**RE: Headrick Garage and Pool Addition (CAO19-014) - Applicant's Response to 9.17.19 City Review Comments**

Wetland Resources, Inc. (WRI) recently received a letter from City of Mercer Island planning staff (date: September 17, 2019, subject line: Review Comments for File No. CAO19-014 - Headrick Garage and Pool Addition 8822 SE 62<sup>nd</sup> Street, Mercer Island, WA 98040; King County Tax Parcel #865050-0040). The letter requests additional information prior to finalizing the application. The following narrative re-states all comments made by City staff as italicized, indented text, which are immediately followed by the applicant's response as justified, normal text. This memo is intended to provide adequate information for City staff to complete review of the Critical Areas Determination for this project.

BUFFER RESTORATION PLANTING PLAN

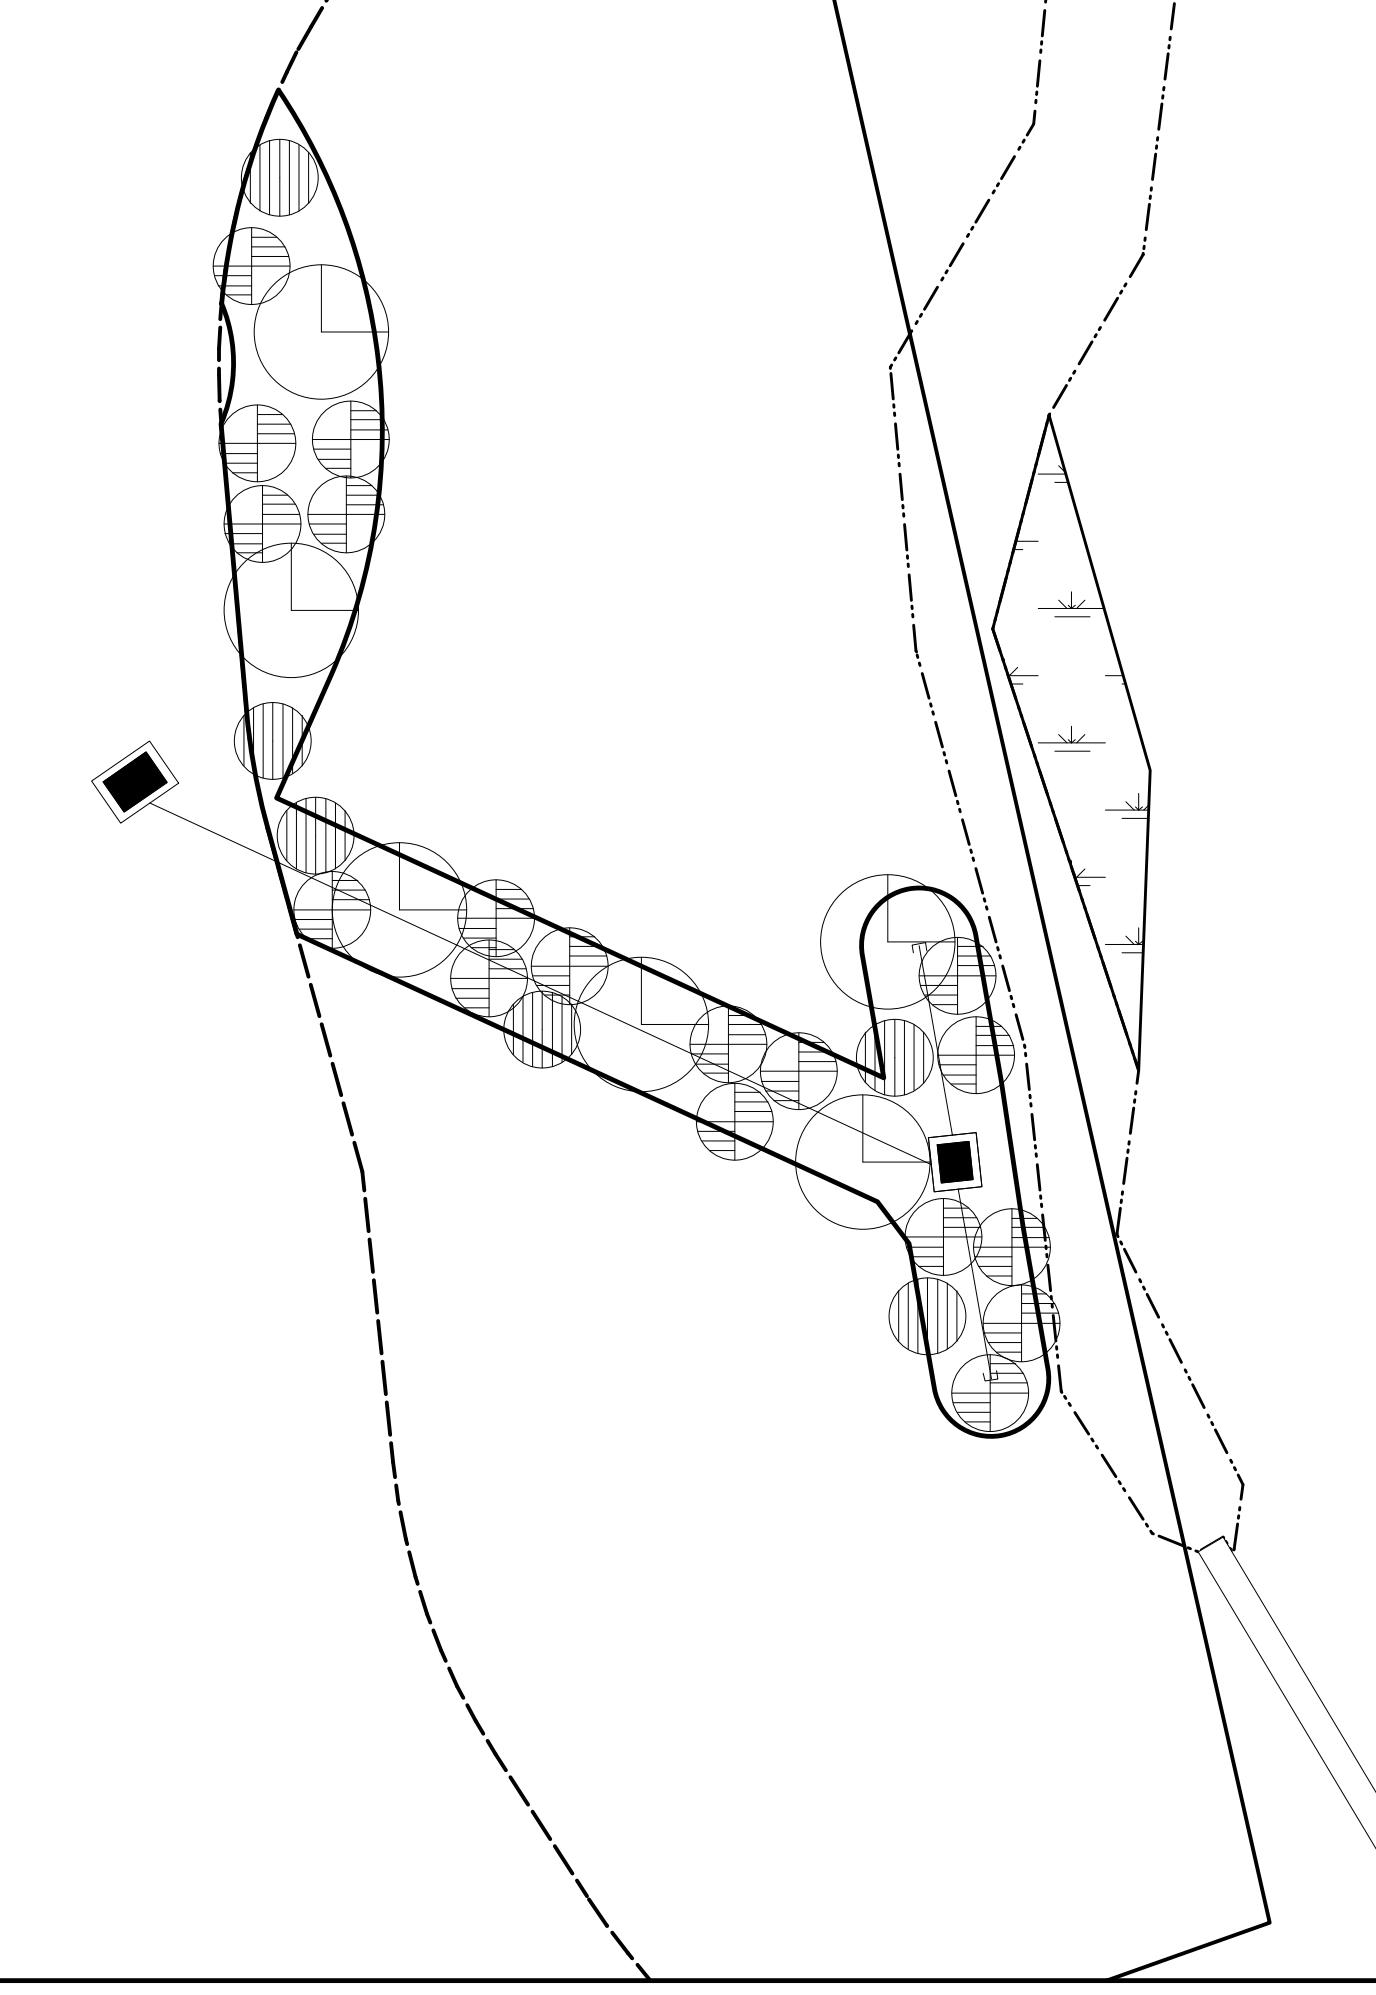
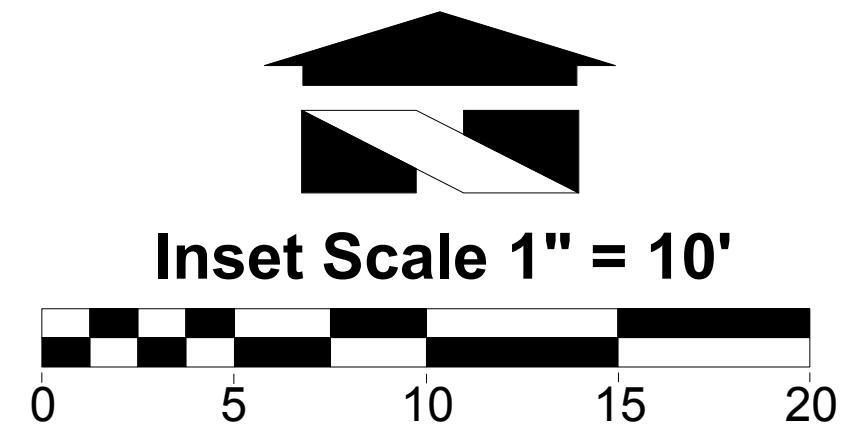
3. According to Performance Standard 1b1 of the Buffer Restoration Plan, installed and native volunteer species shall achieve 50 percent aerial cover by Year 5. Please increase aerial cover to 70 percent as 50 percent aerial cover is a low requirement for Year 5 aerial cover performance standards. To help achieve 70 percent aerial cover by Year 5, the following is recommended based on the proposed plantings and quantities: increase the density of proposed plantings (e.g. use 4-foot spacing for shrubs and 2-foot spacing for groundcovers); and/or install additional salmonberry plantings rather than strawberry groundcover plantings.

**Applicant's response:** Areal cover has been increased to 70 percent for Year 5 in the revised Critical Area Study. See Page 15 (Section 5.1 Goals, Objectives, and Performance Standards).
